from
**Southern
Water**

Our ref
PLAN-032176

Proposal: Conversion of house into 2 No. Self contained flats.

Site: LU/2/20/PL: - 51 Falkland Avenue, Littlehampton, BN17 6AB.

Block Plan

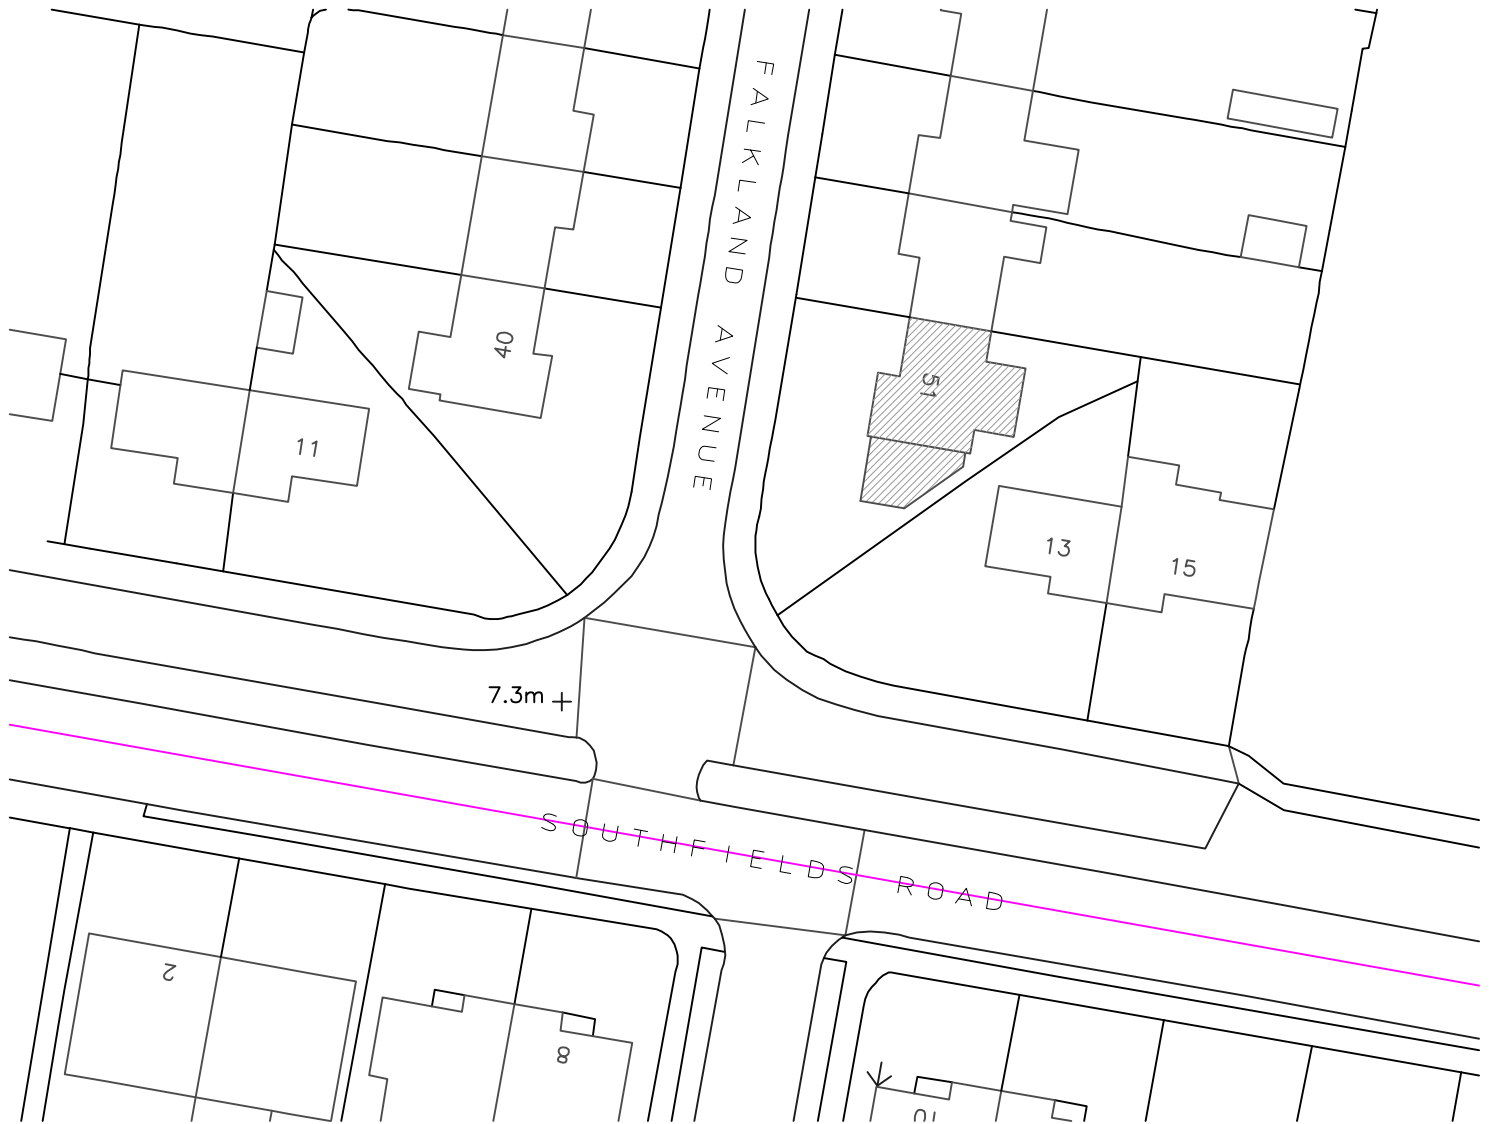
Please find attached a plan of the sewer records showing the approximate position of a public combined sewer crossing the site. The exact position of the public sewers must be determined on site by the applicant before the layout of the proposed development is finalised.

- The 150mm diameter gravity combined sewers requires a clearance of 3 metres on either side of the gravity sewers to protect it from construction works and to allow for future access for maintenance.
- No development or tree planting should be carried out within 3 metres of the external edge of the public gravity sewer without consent from Southern Water.
- No soakaways, swales, ponds, watercourses or any other surface water retaining or conveying features should be located within 5 metres of a public sewers.
- All existing infrastructure should be protected during the course of construction works.
